**Re: SSD-10473 – Marist Catholic College North Shore
270 Miller Street, North Sydney
Response to request for further information**

Rooftop design amendment

Drawing No. DA-109	Issue E
Scale 1 : 200	Drawing Size A1
Project No. 18165	Drawn By BE

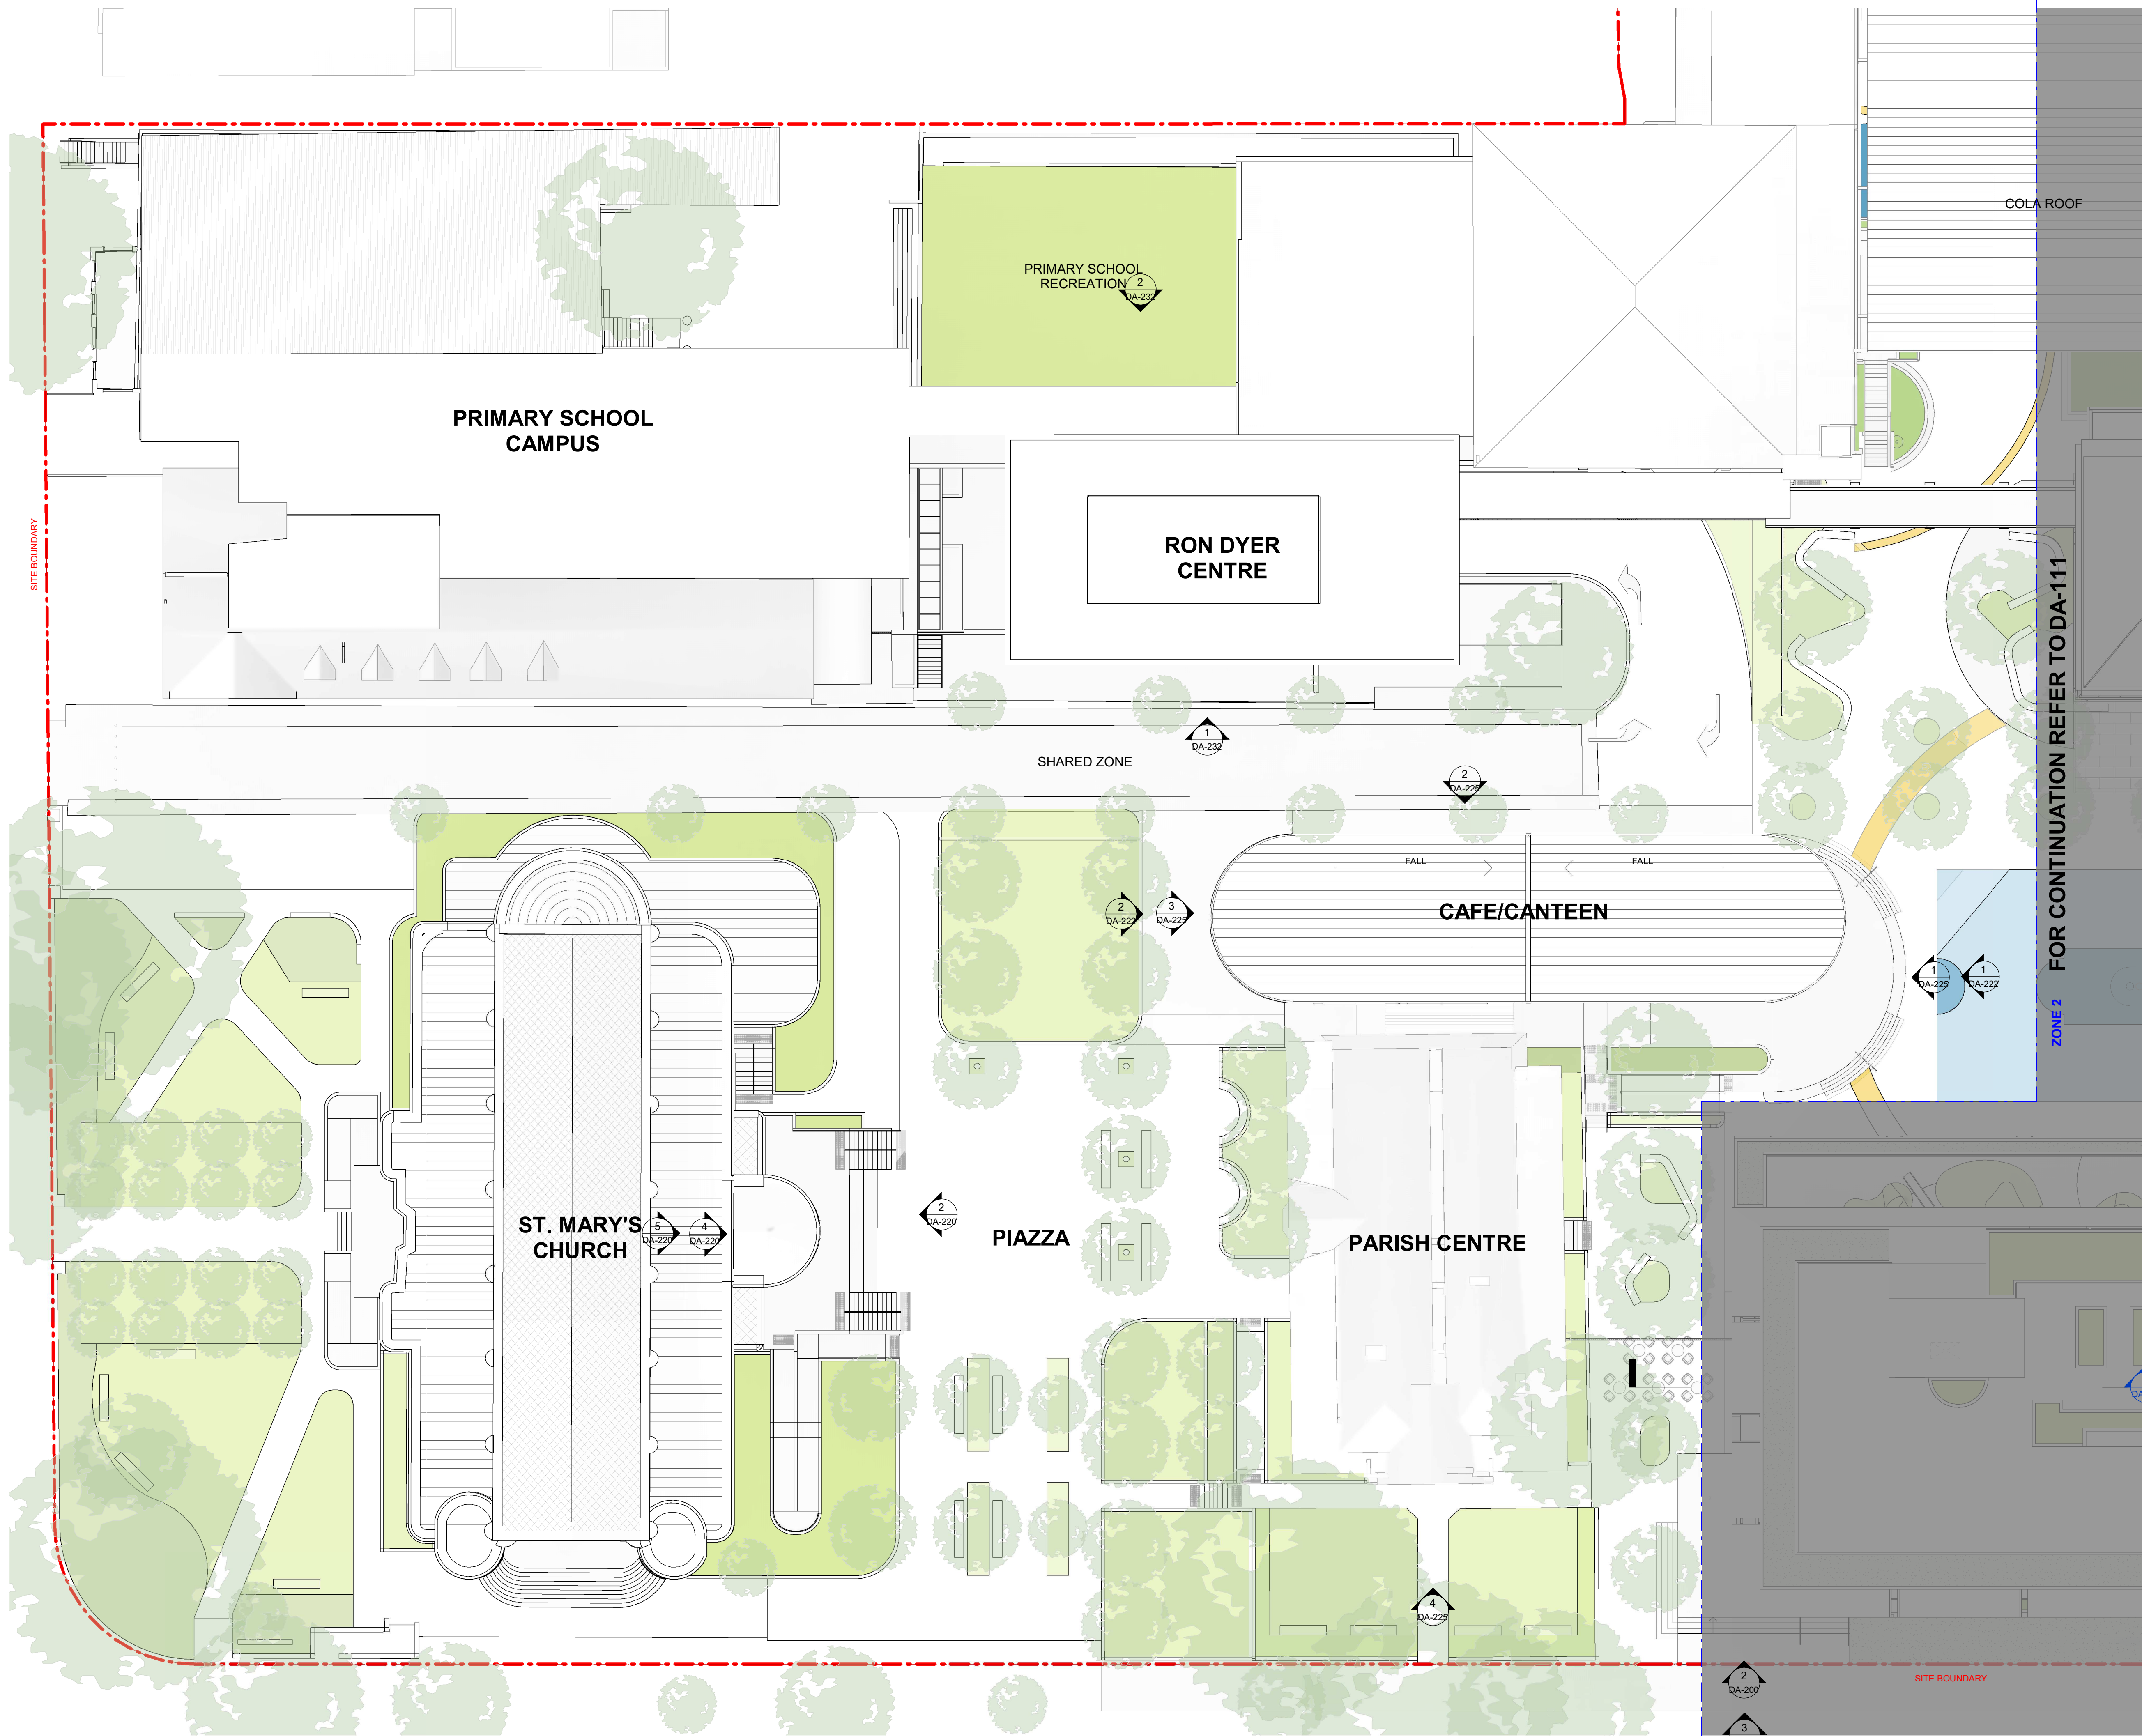
As a result of ongoing design development, the Applicant has determined that the size of the plant room on the roof of Carlow Street Building may not be adequate in size, and therefore propose to a second rooftop plant room adjacent to the fire stair. The additional plant room will not cause any major visual impact, as it sits under the line of the solar panels and nestled between landscape planting, the atrium pop-up louvres, and the fire stairs.

In order to reflect this change to the rooftop design, the Applicant requests that the schedule of drawings in Condition A2 be updated to refer to the following:

- DA-000 [E] 18/08/22
- DA-021 [E] 18/08/22
- DA-109 [E] 04/08/22
- DA-111 [B] 04/08/22
